# Final Plat Drawings\_v2.pdf Markup Summary 11-3-2022

FALCON MEADOWS AT BENT GRASS FILING NO. 4

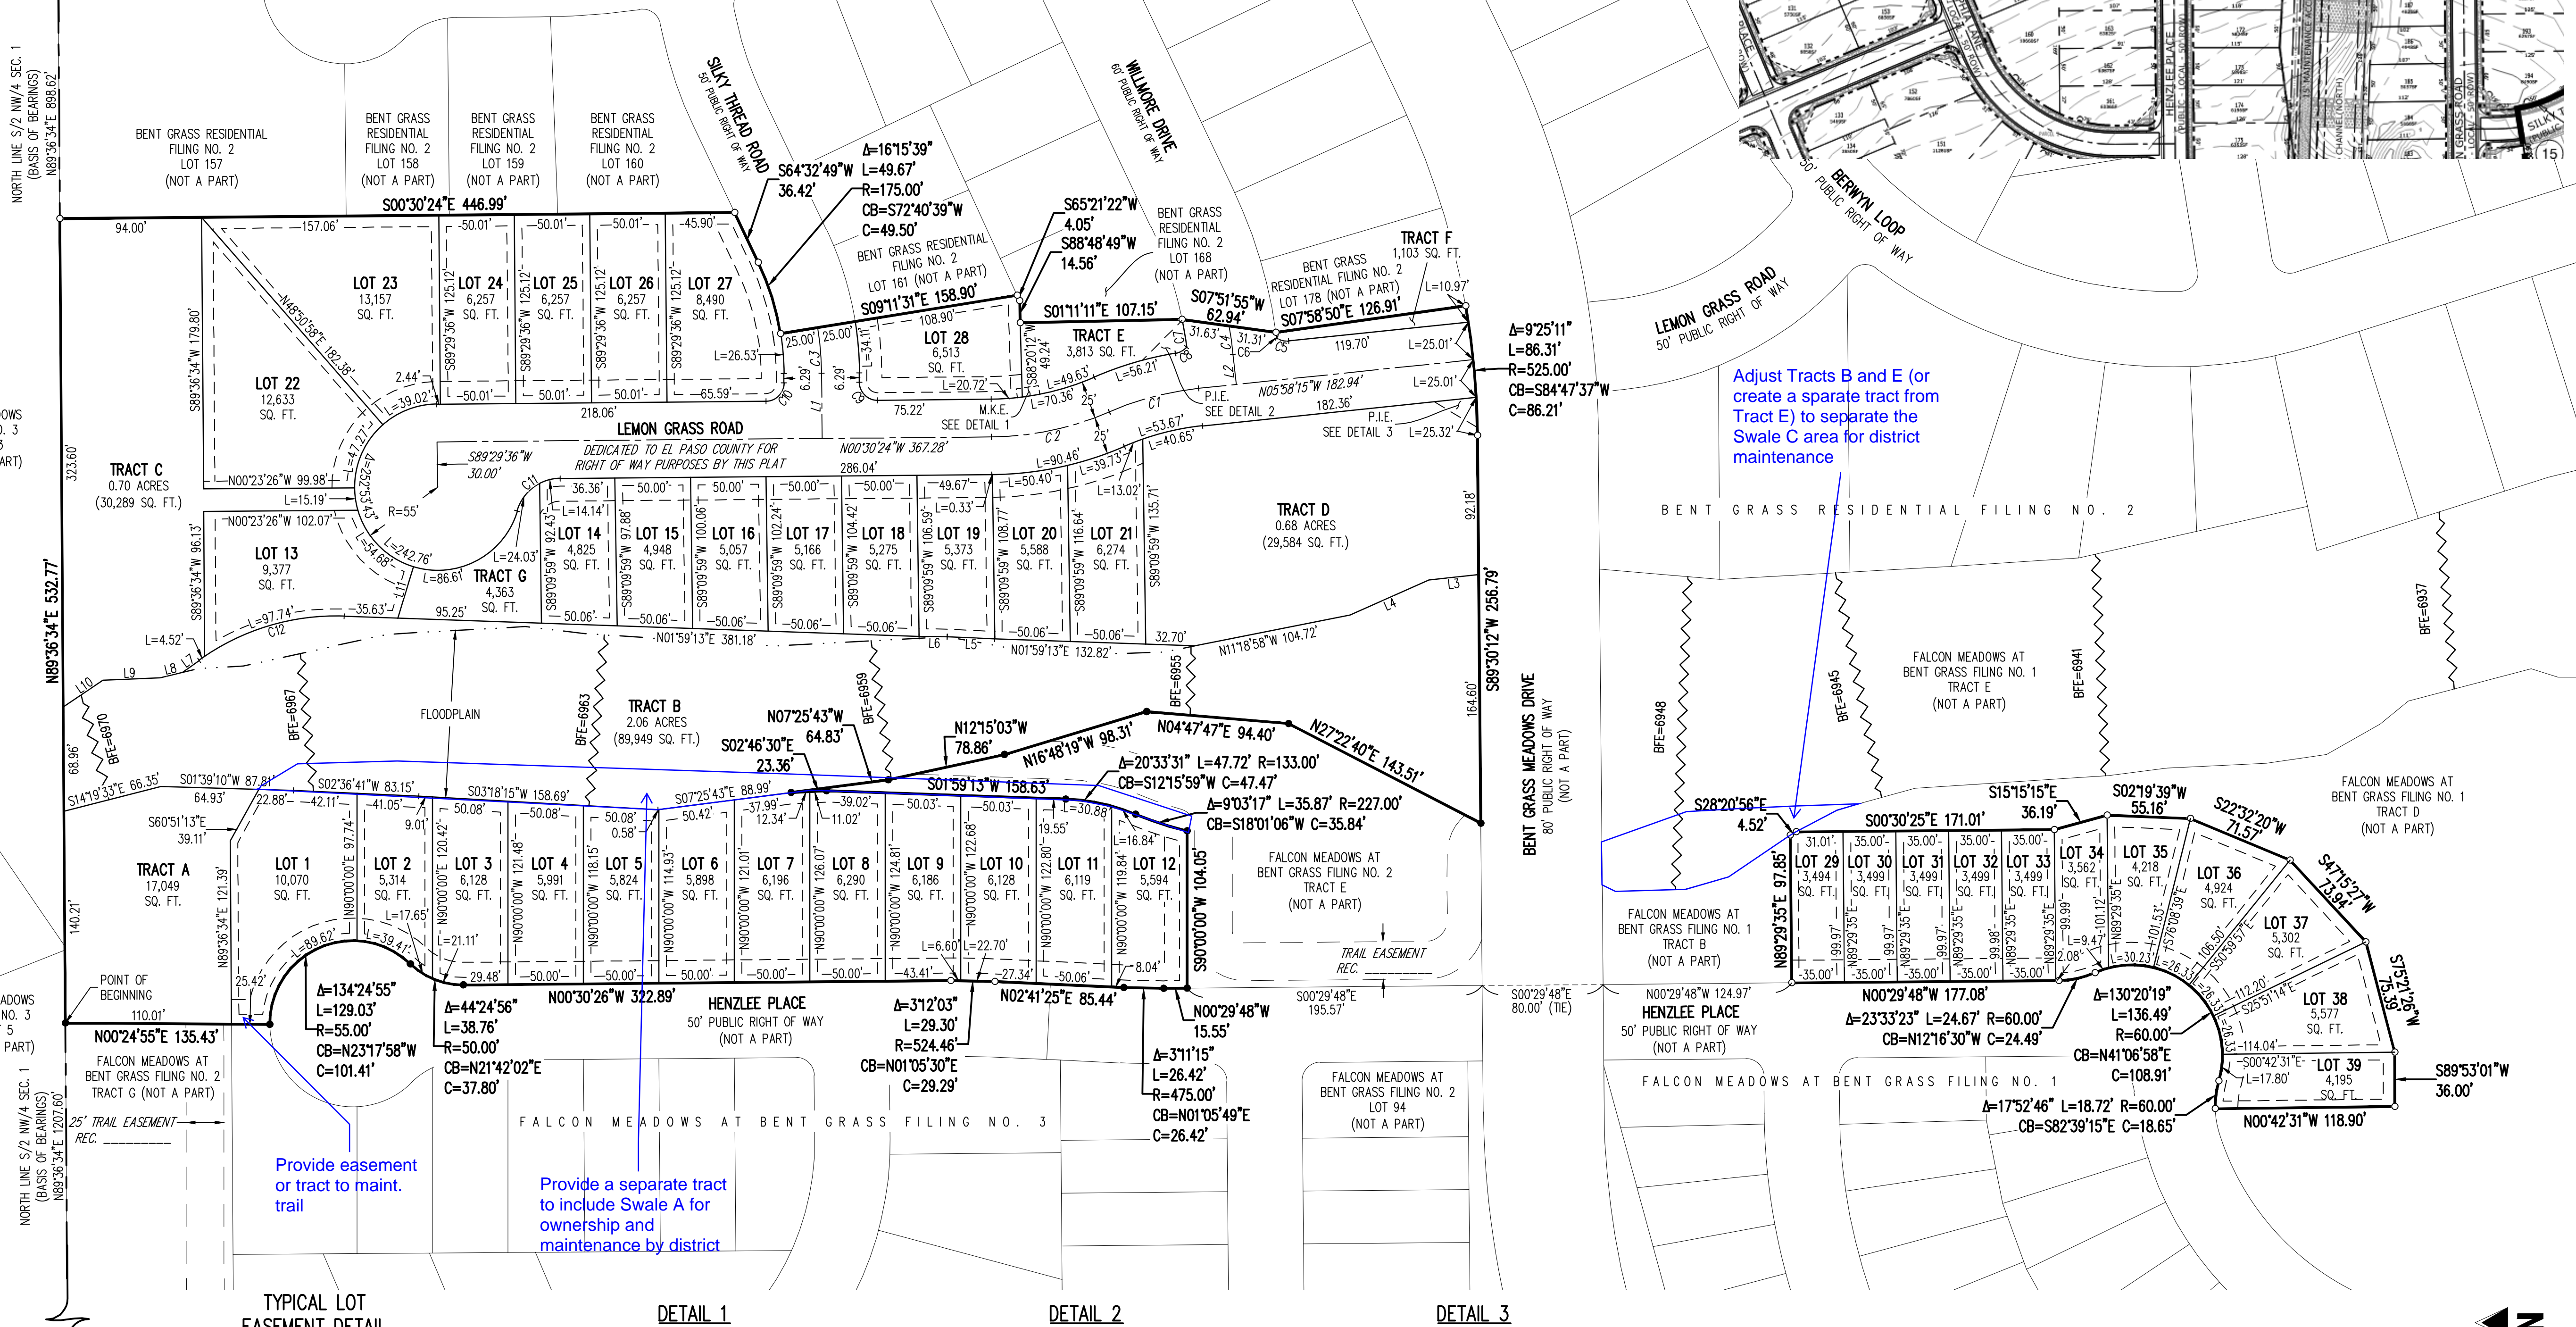
separate the tracts from the County will own and what is privately owned and District owned along channel- this may create an additional tract as result of channel design and FDR reprot

Add Tract B  
adjustment

Add Tract B adjustment

OVERALL SHEET

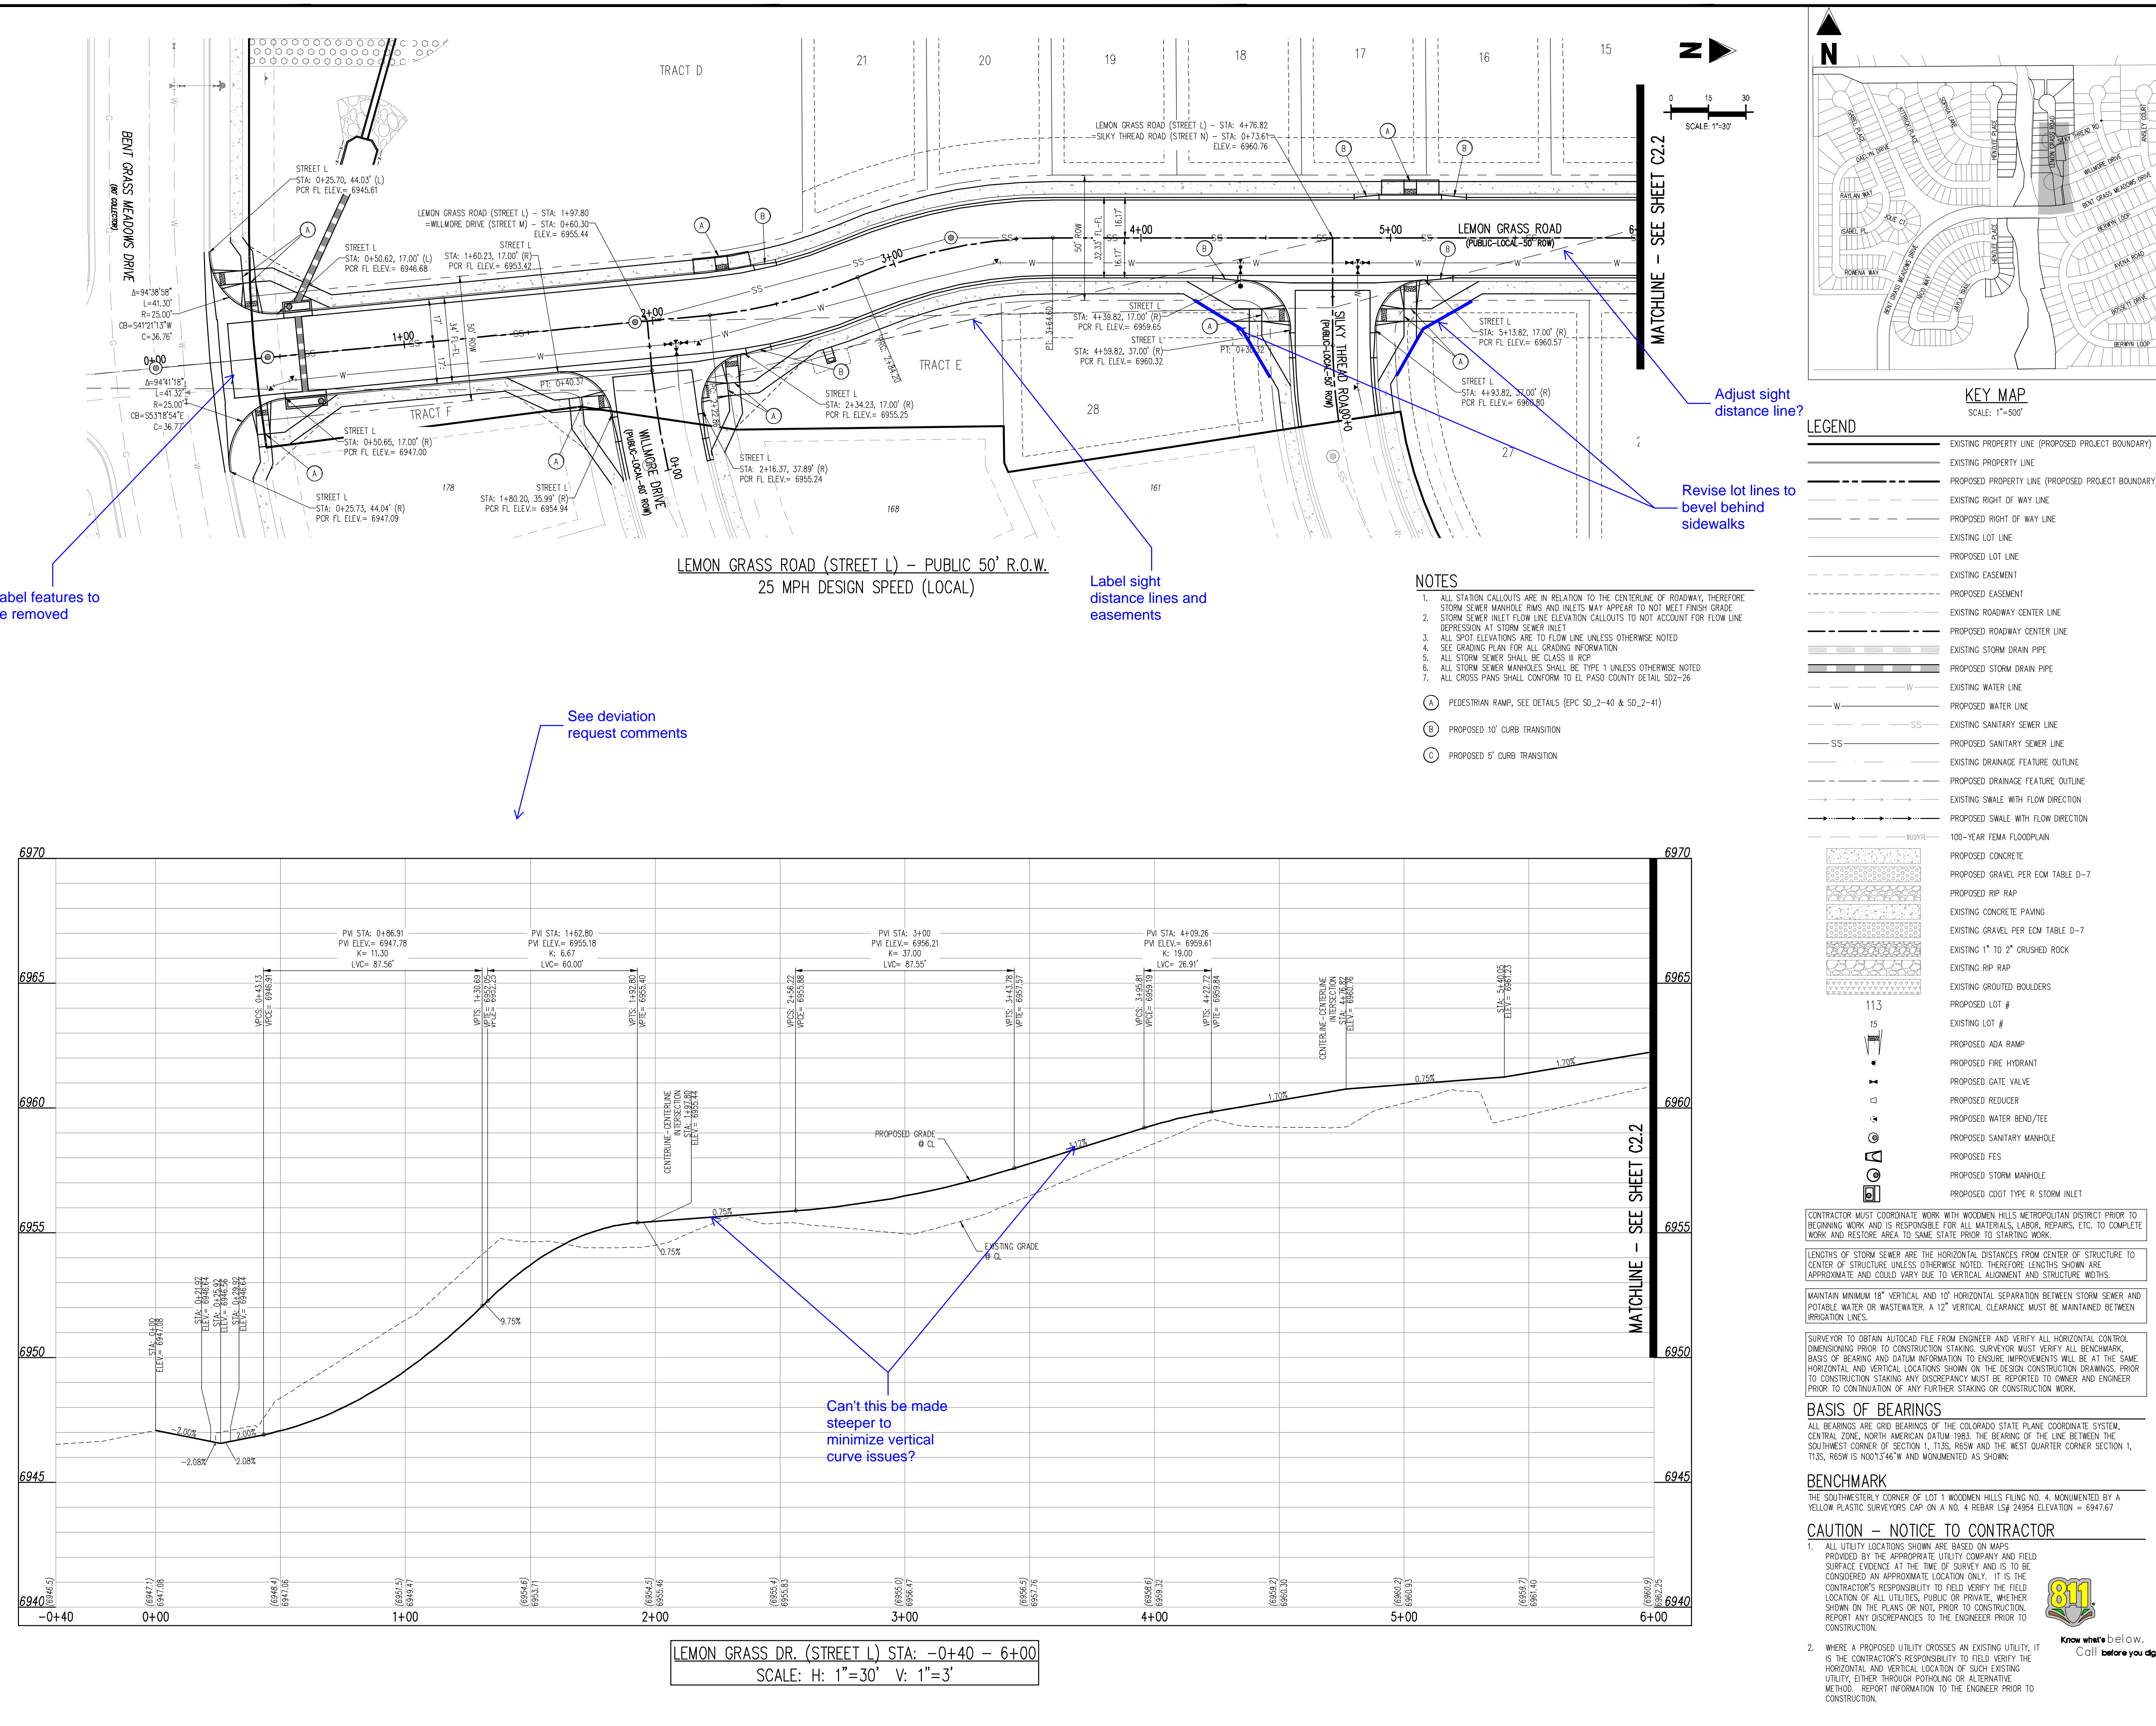
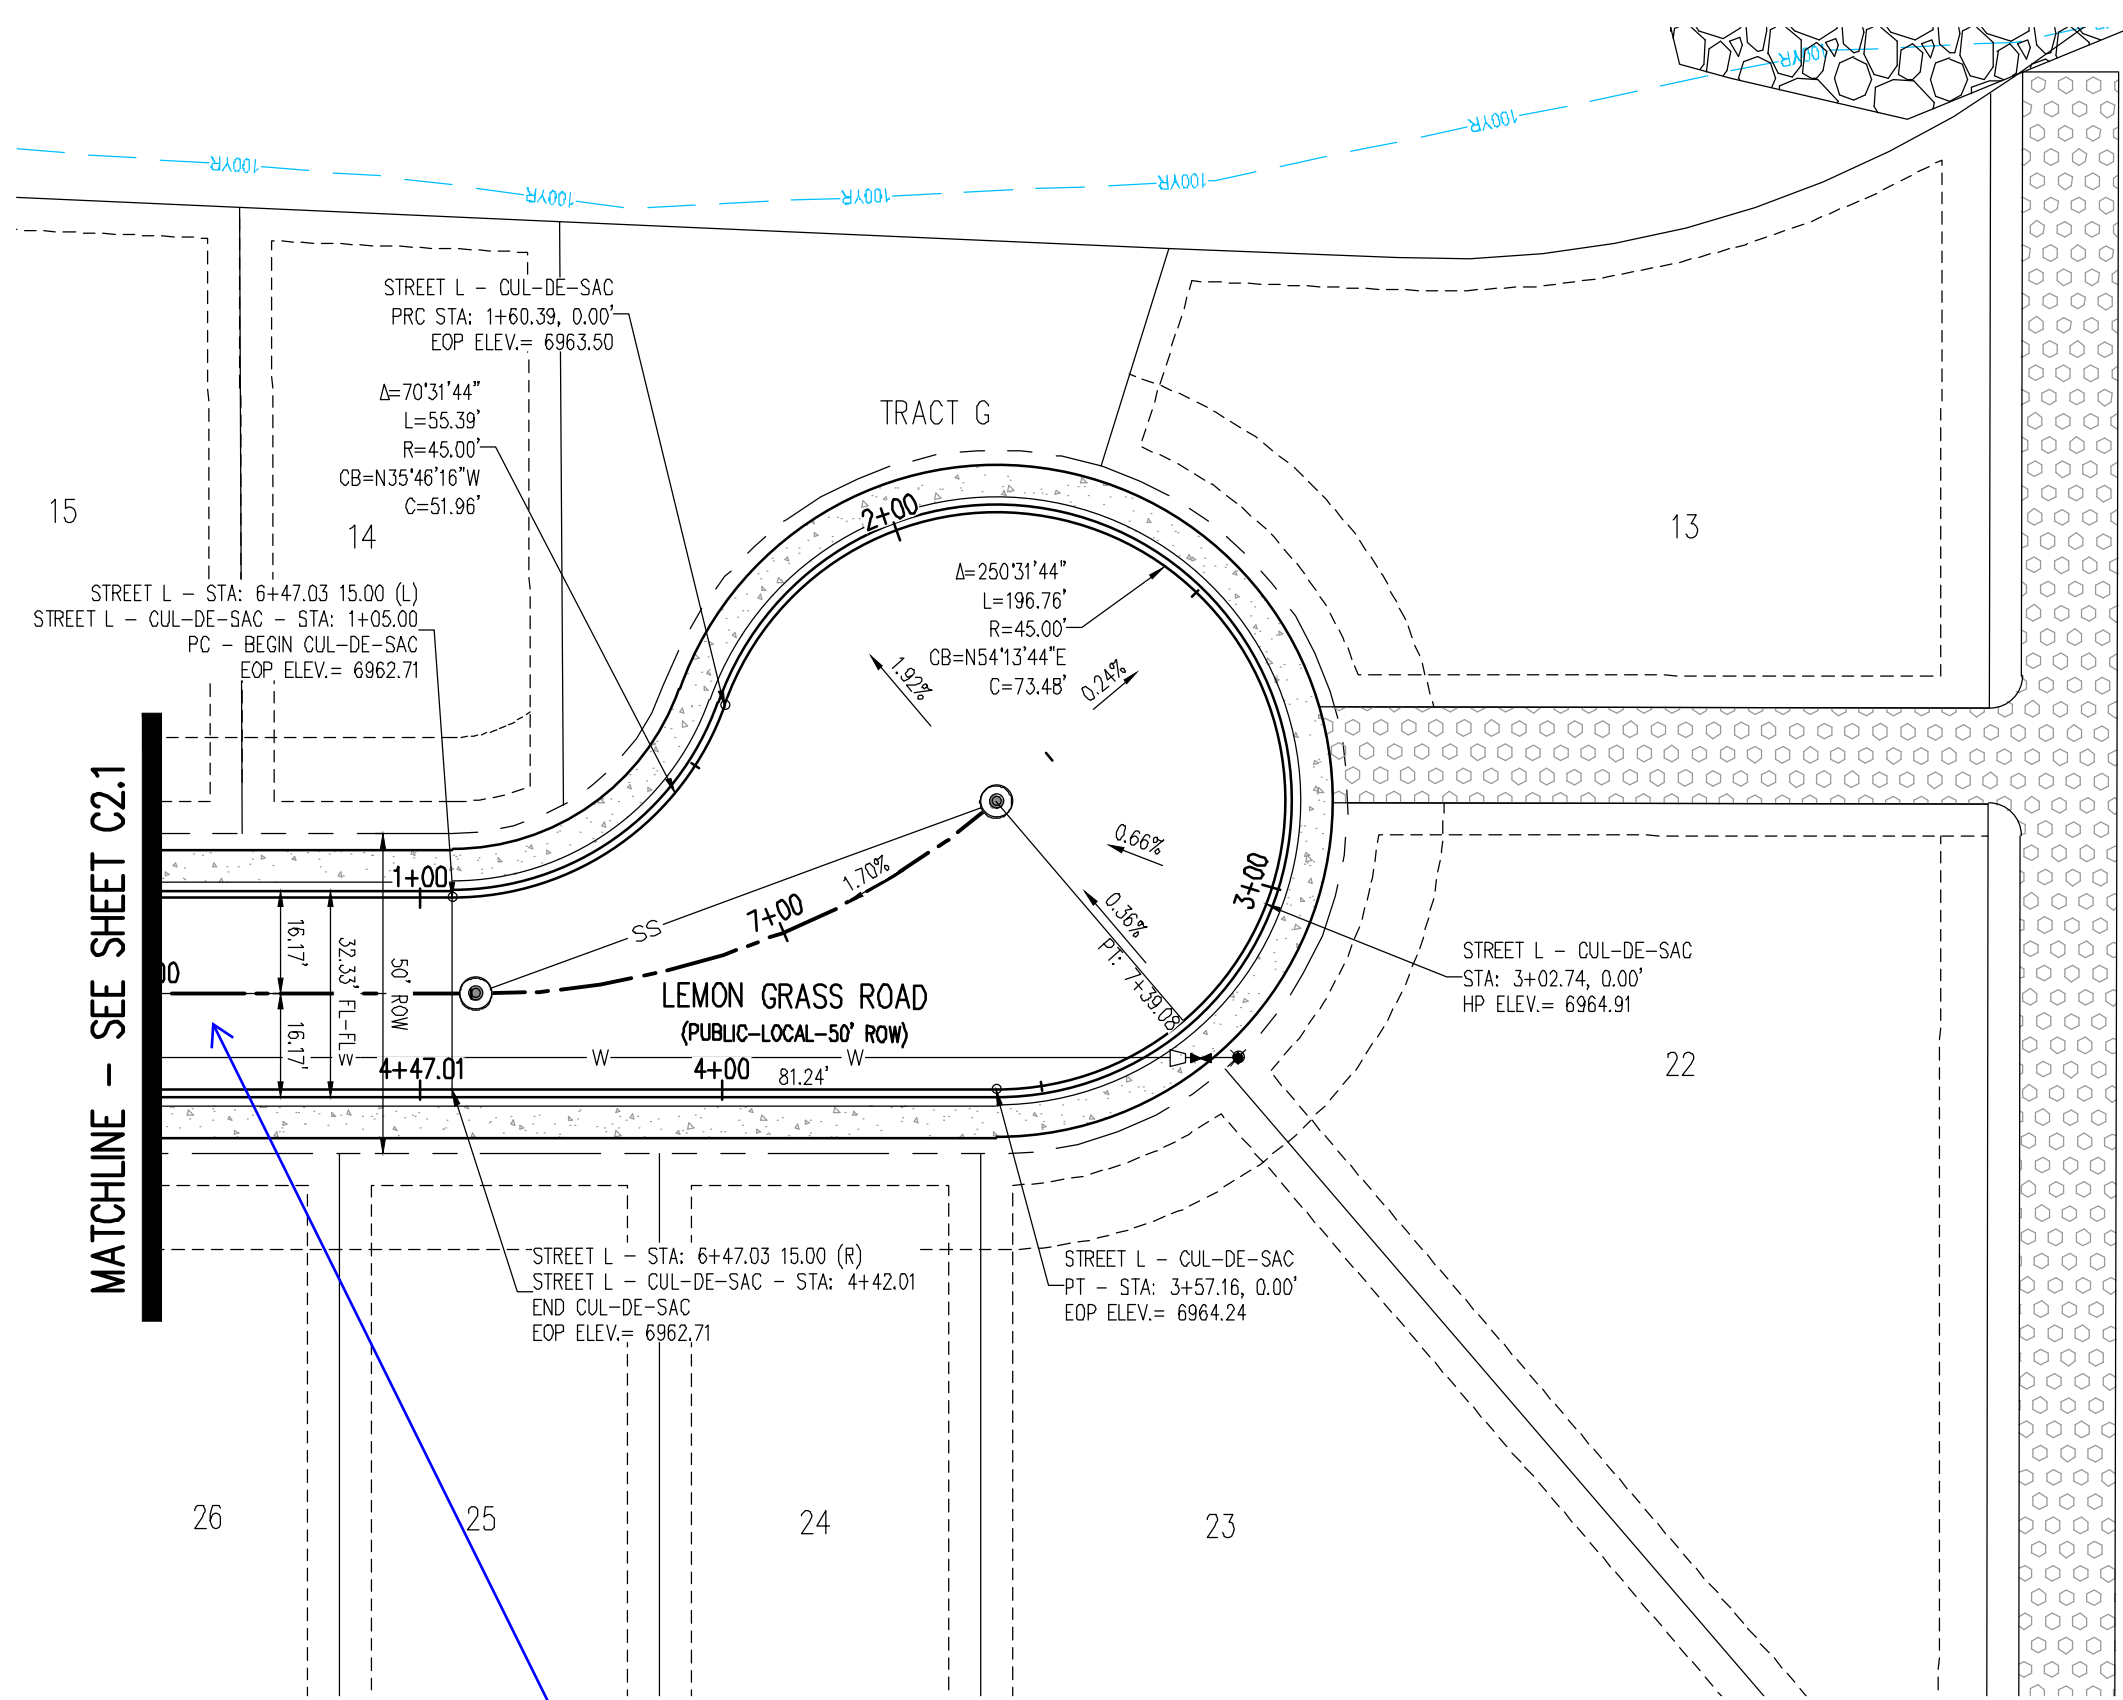
Revise lot lines to bevel behind sidewalks at corners
